Our Ref: FP/251/19/PL

**Town & Country Planning Act 1990 (as amended)
Town and Country Planning (Development Management Procedure) (England) Order 2015
Application for Planning Permission**

Development Altering of existing west access to site to allow for vehicular access for emergency & maintenance purposes only. Drop kerb formed to allow for vehicular crossover, area to include a new area of secure bin storage for the school.
fence off waiting area separating it from public access & existing vehicular entrance areas.

Location Bishop Tufnell C Of E Junior And Infant School Pennyfields Felpham

notes:

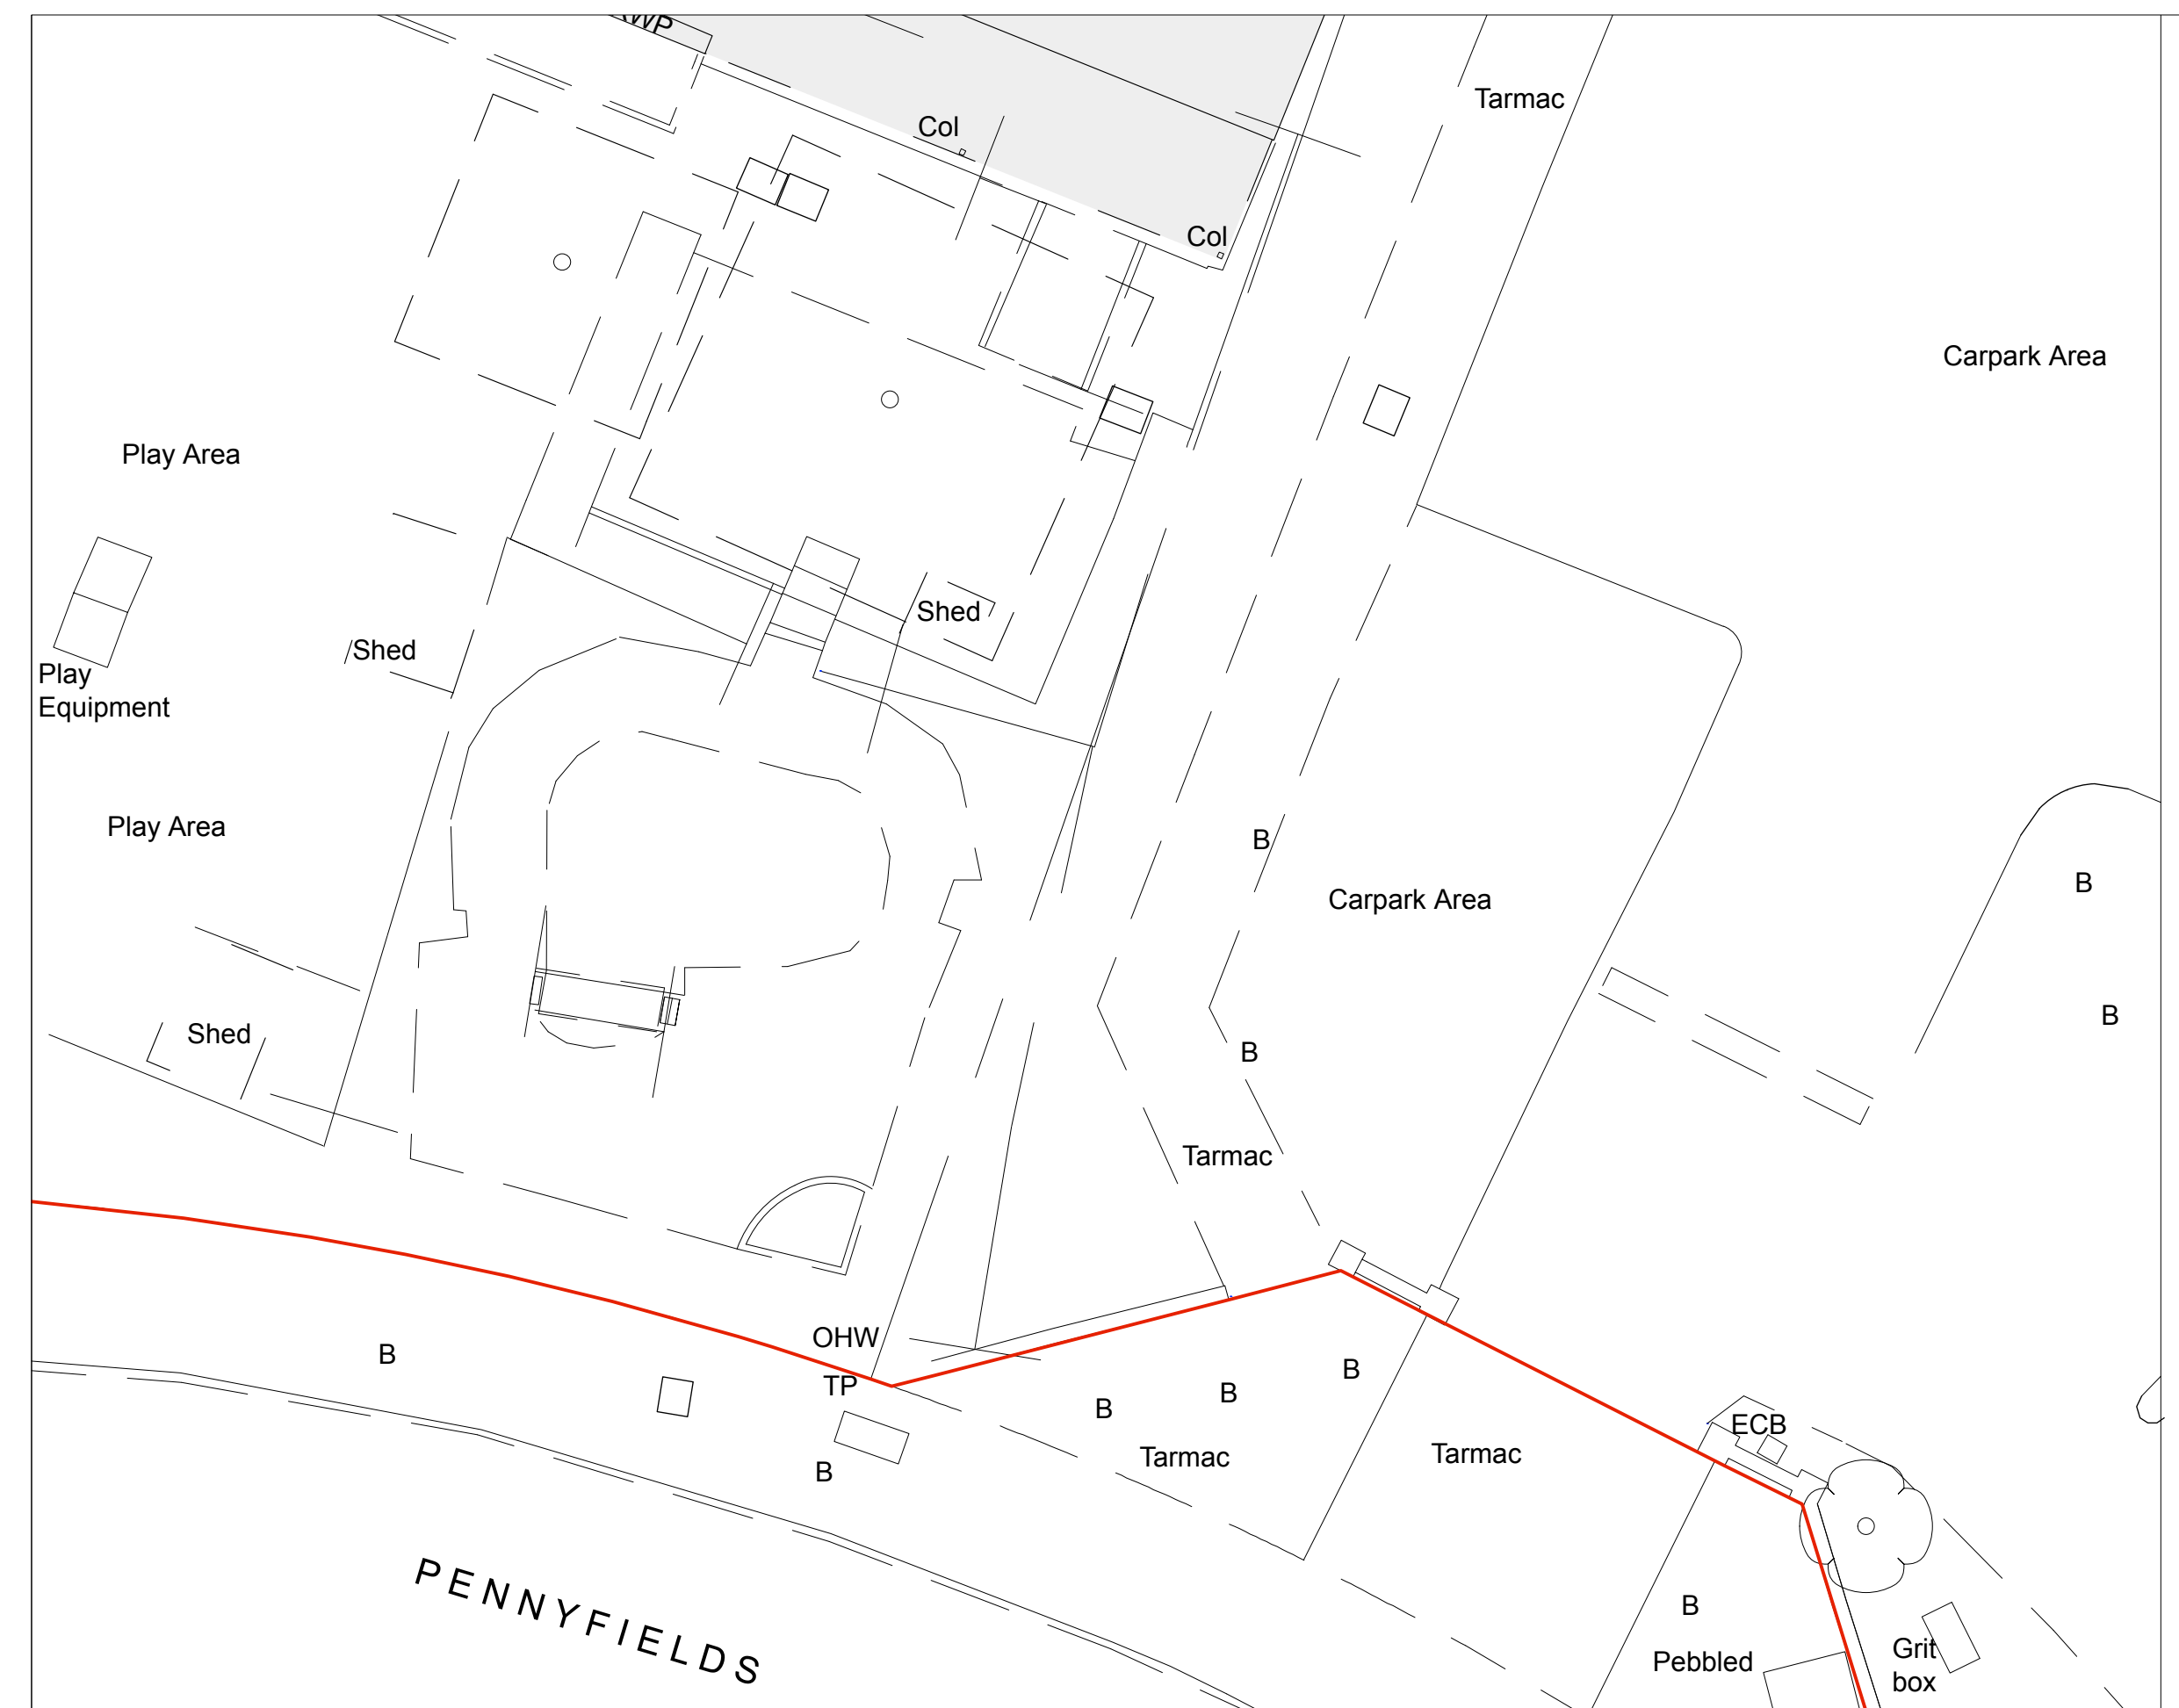
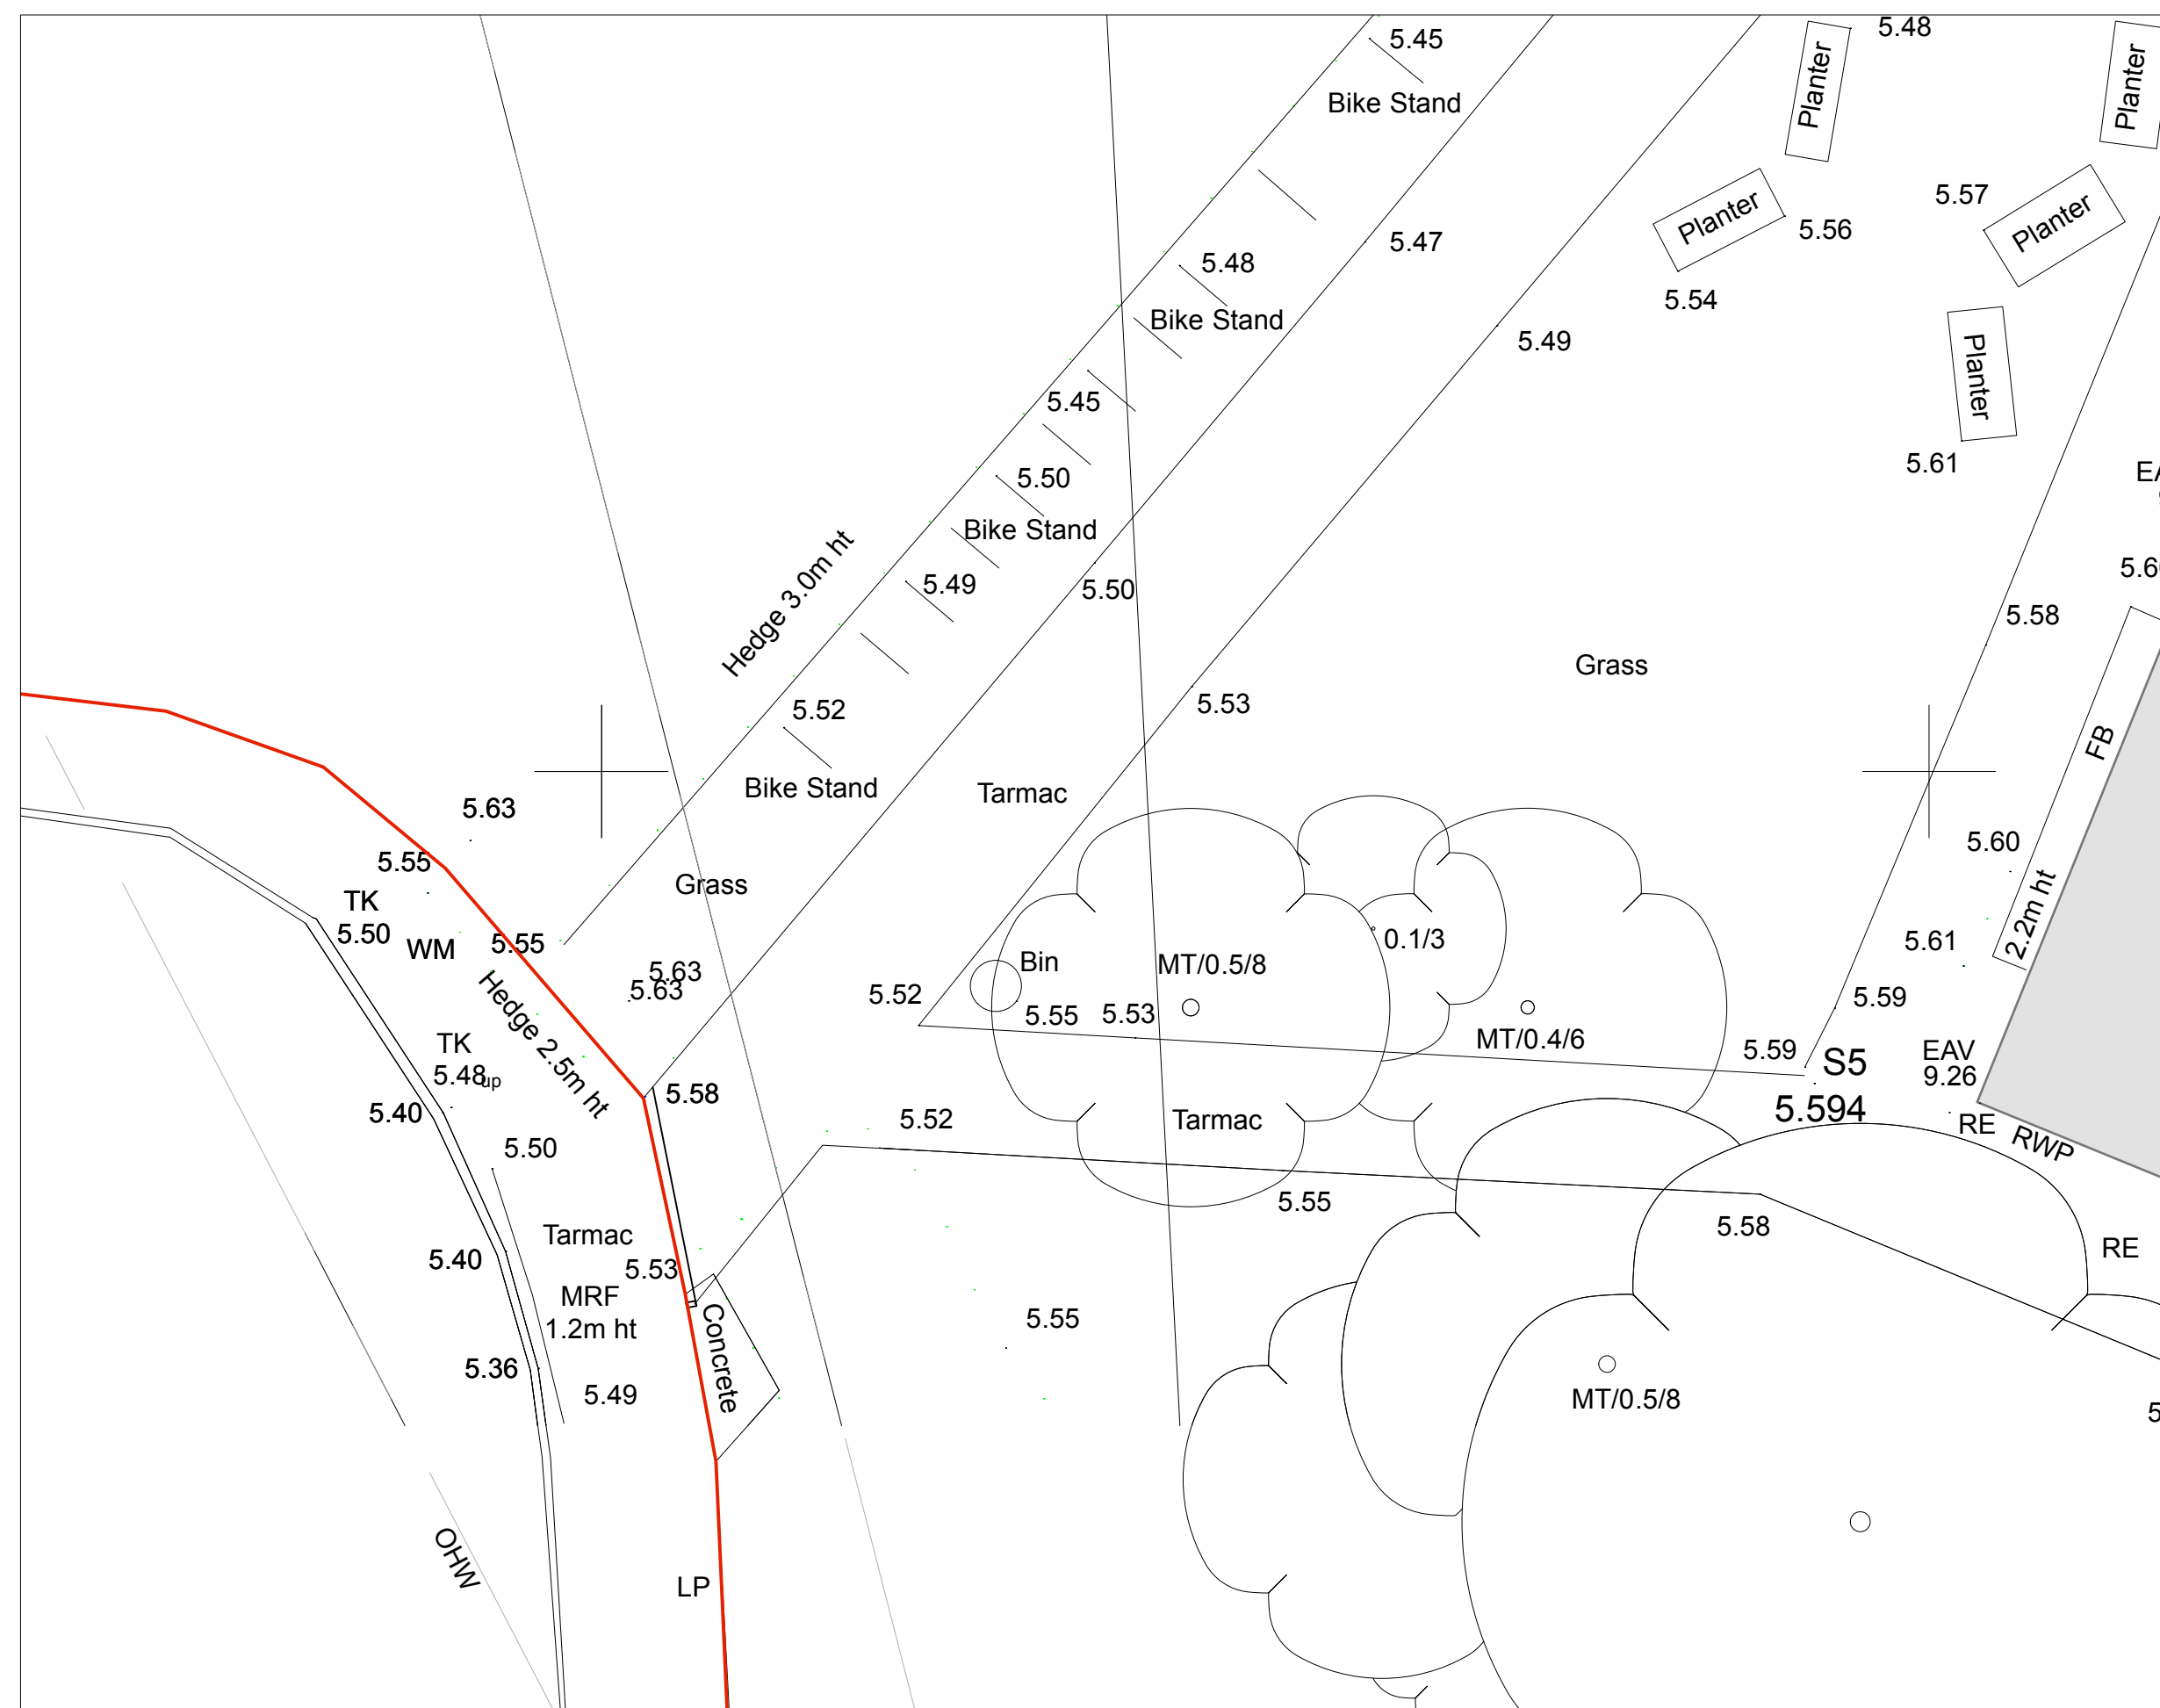
West Sussex County Council require that a visibility splay is provided. A splay is formed for a 30 mph speed limit road by measuring from a point 2.4m back from the kerb edge in the centre of the proposed access. A line should then be drawn from either side of this point for 43 m in each direction to the nearside edge of the carriage way. The splays must intersect land

only within the control of the applicant, or within the publicly maintained highway.

The distance will increase with the speed limit of the road. If the road is 40 mph speed limit then the distance should be 120 m either side. For speeds above this please contact West Sussex County Council Highways for advice on what would be acceptable.
